PCU048448

ROCKY HILL COAL PROJECT - Application No. SSD 5156

Figure 4.1 Annual and Seasonal Wind Roses for the Rocky Hill Coal Project (July 2010 – June 2011 and July 2011 – June 2012)

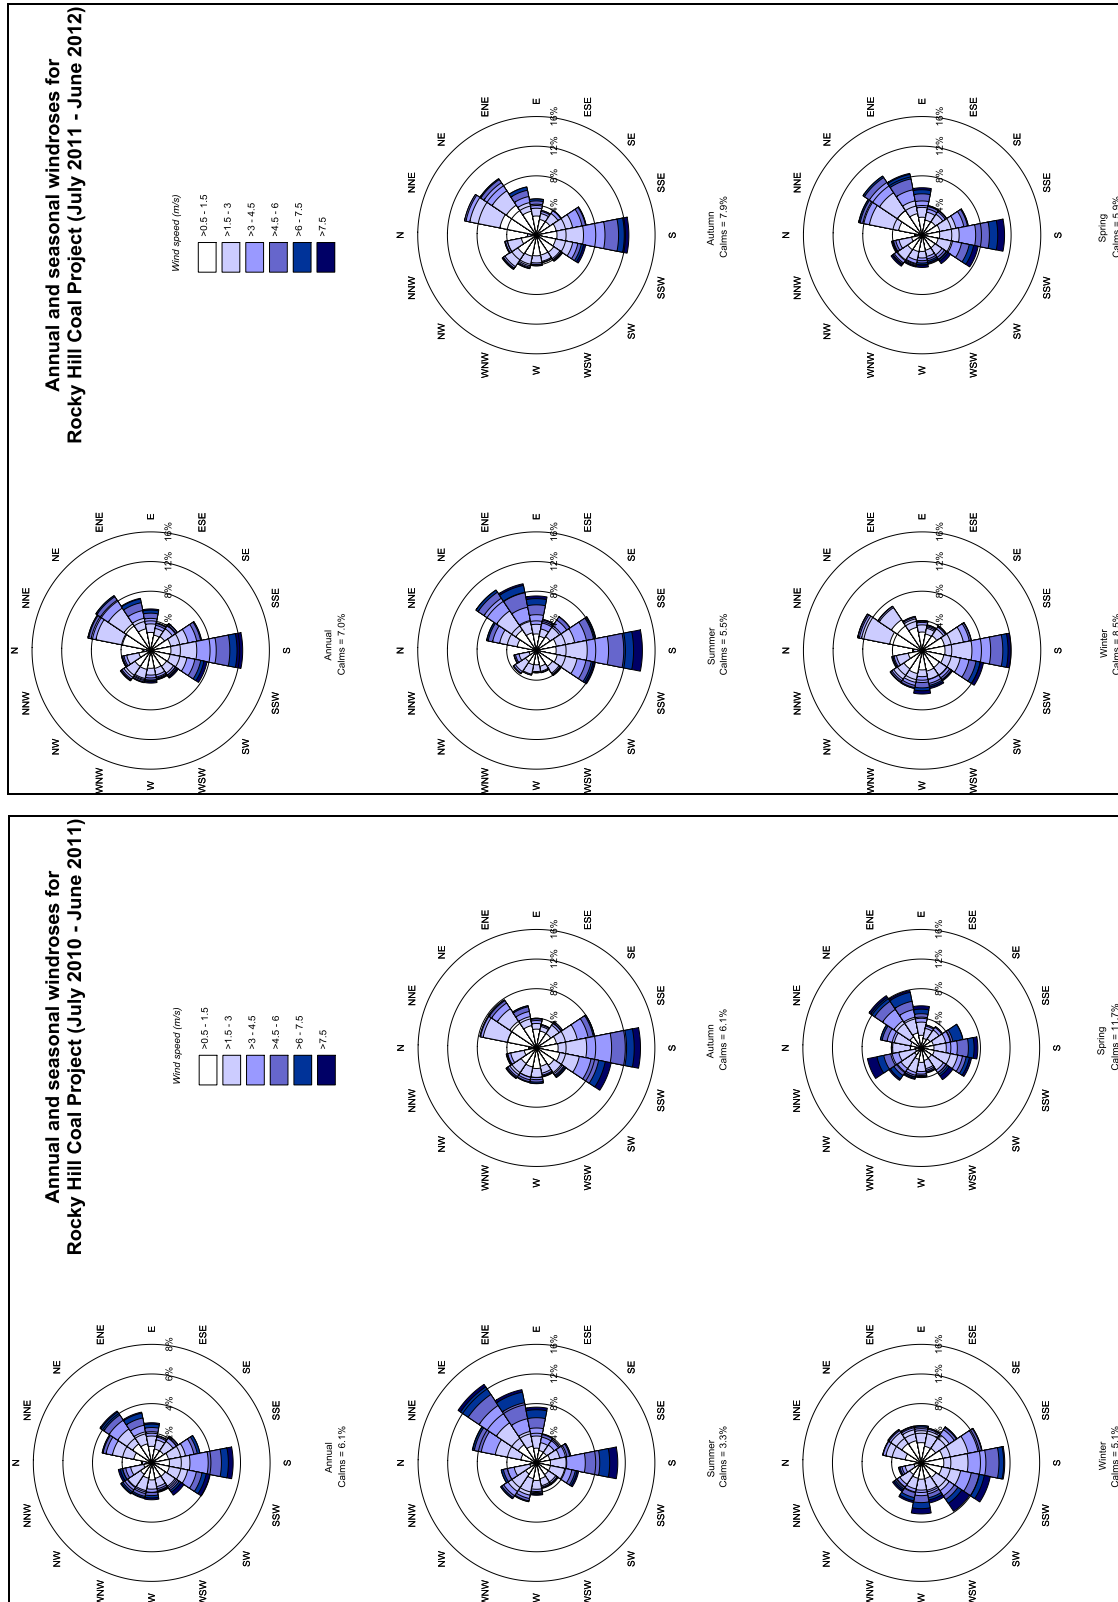
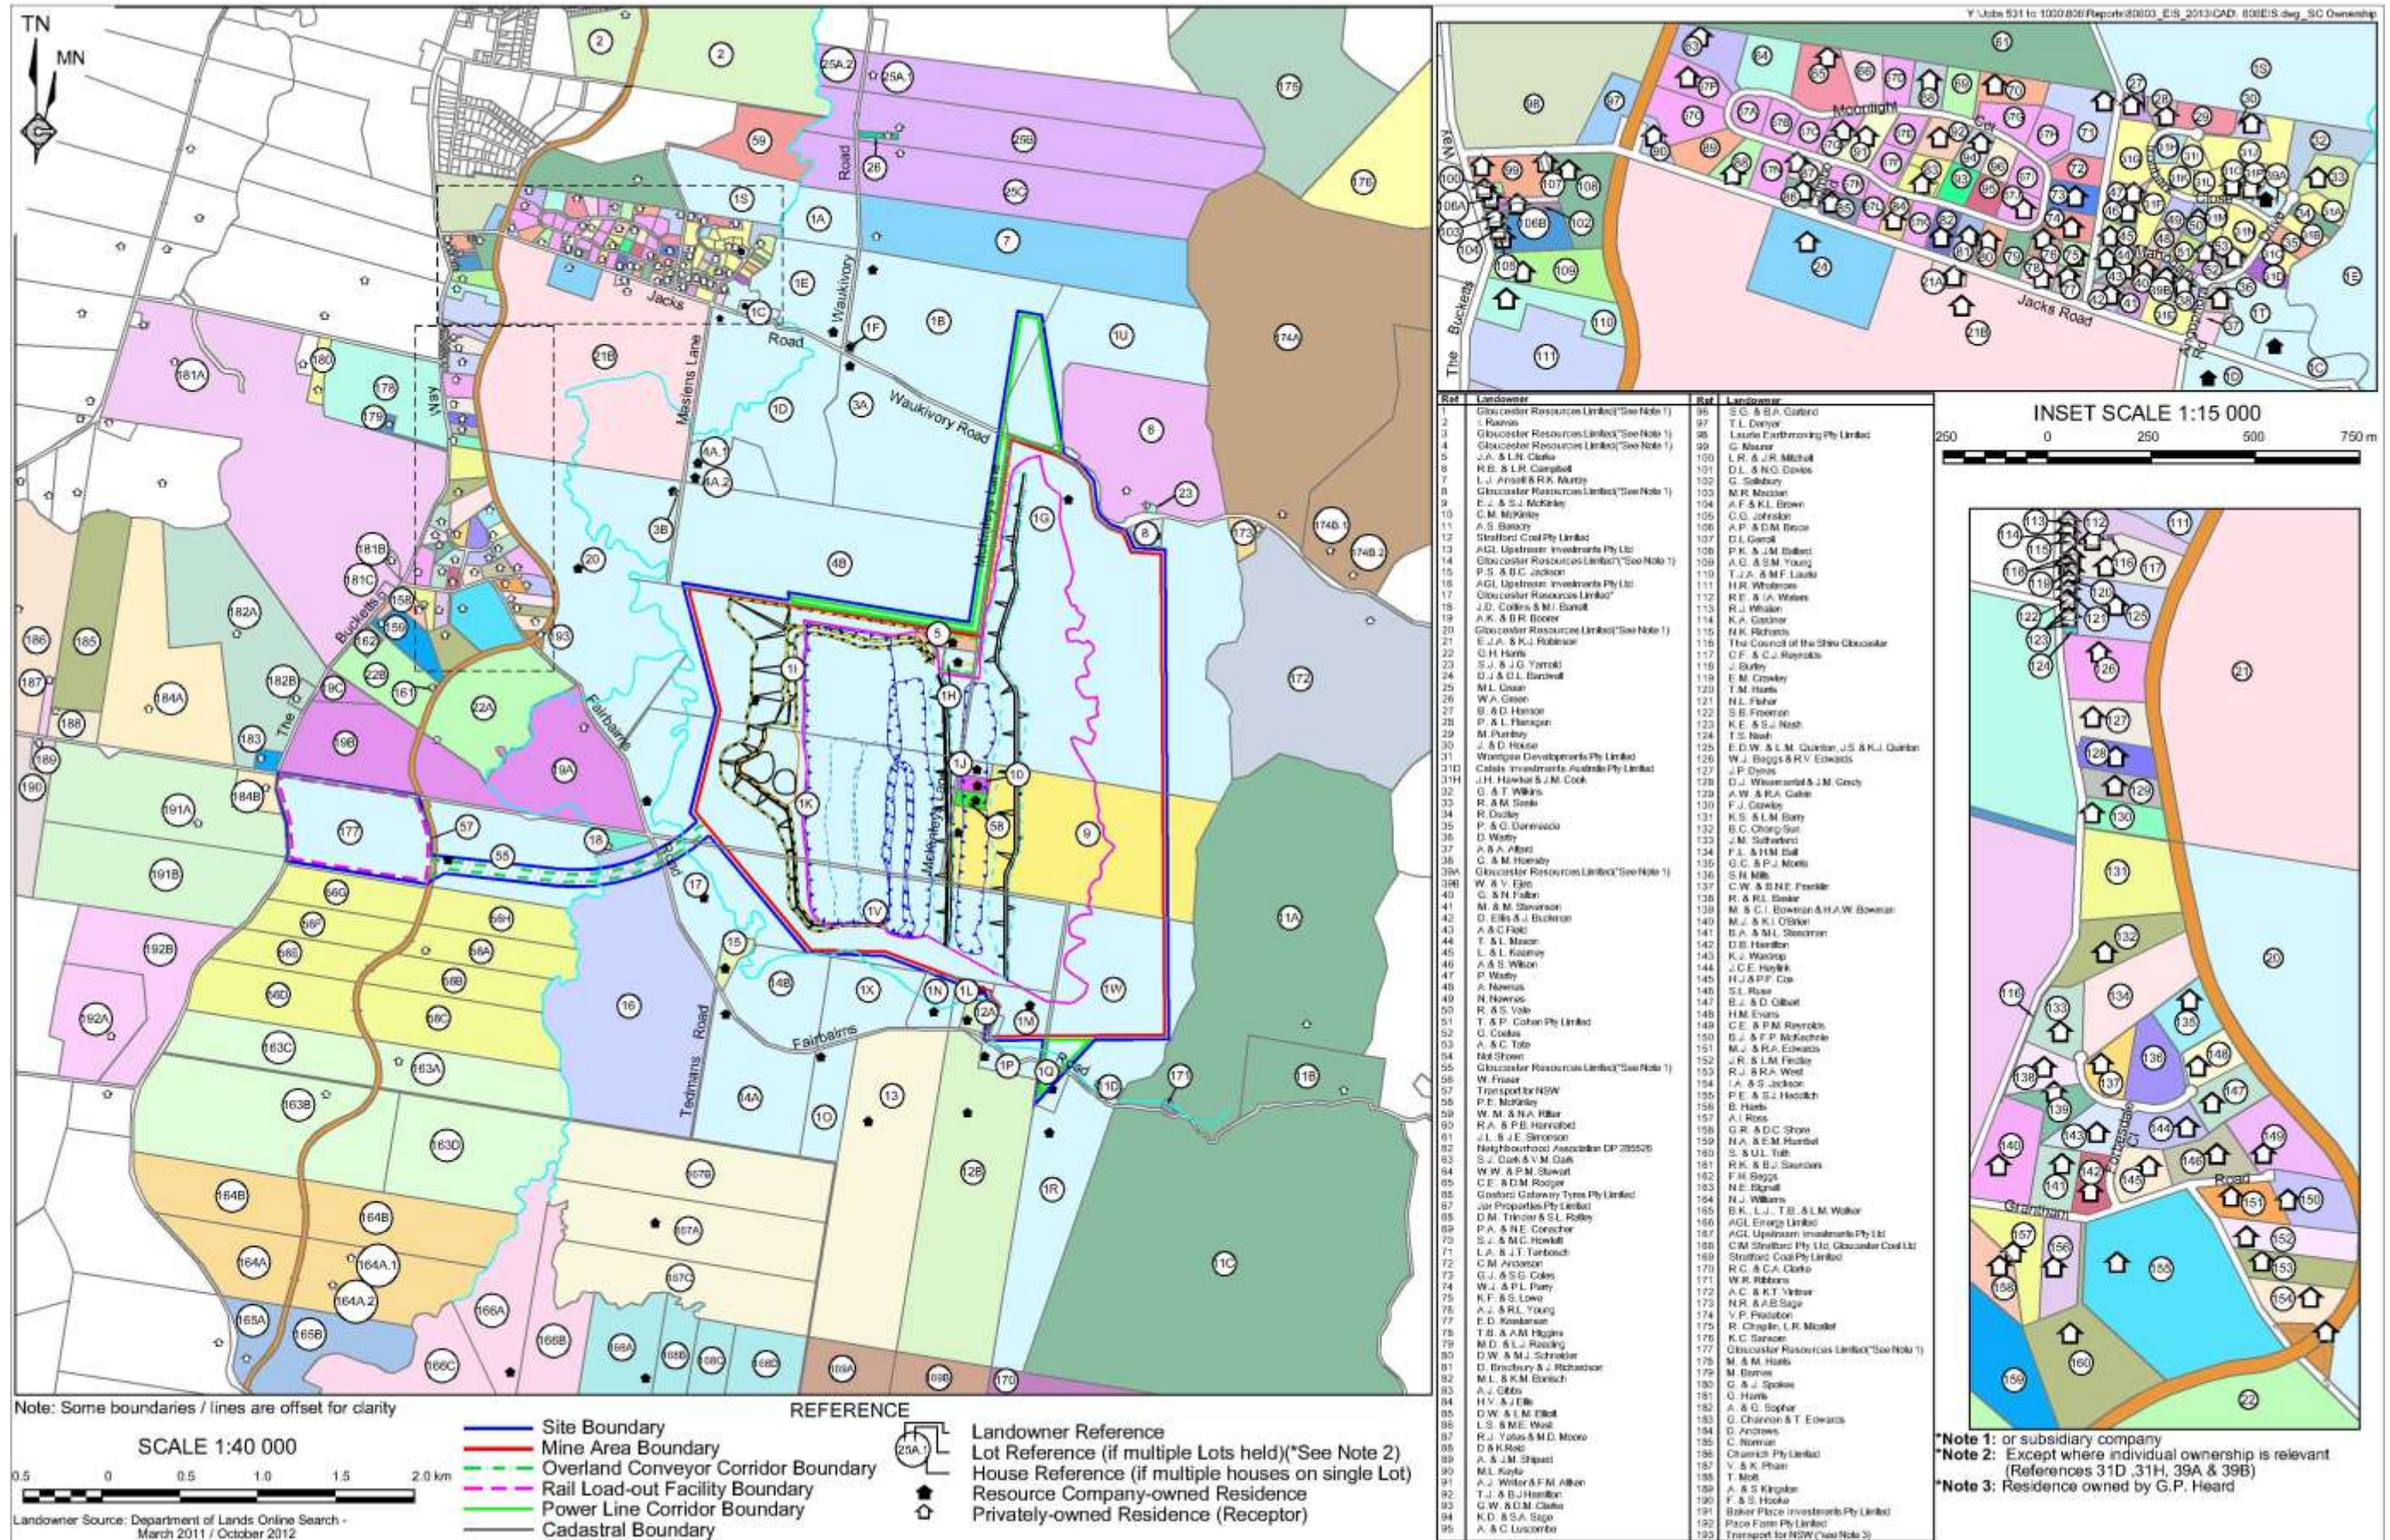
A major concern is the risk to human health for the nearby residents and the people of Gloucester. Wind rose diagrams in the Specialist Consultants Studies Compendium (SCSC 2B-26 Fig. 4.1) show prevailing winds are predominantly from the south, a fact not properly disclosed in the Environmental Impact Statement (EIS). Southerly winds will blow airborne pollutants toward Gloucester Township.

The proposed Rocky Hill mine will produce nearly 7 tonnes of PM10 particles per week at peak production which will include a considerable amount of diesel particulates. Gloucester therefore has southerly winds predominating with temperature inversions common during winter. These winds will blow this pollution towards and over Gloucester. Although the EIS states (4.4.9.5) *"The conservative assessment of the potential acute and chronic health risks of increased levels of PM2.5 and NO₂ associated with the Proposal has established that the potential health risks are negligible or acceptable at the receptor with the highest impacts expected."* I cannot comprehend how anyone could arrive at such a conclusion. I believe the **potential acute and chronic health risks** are anything but negligible or acceptable. Gloucester residents are not expendable. In my opinion this mine must not be approved.
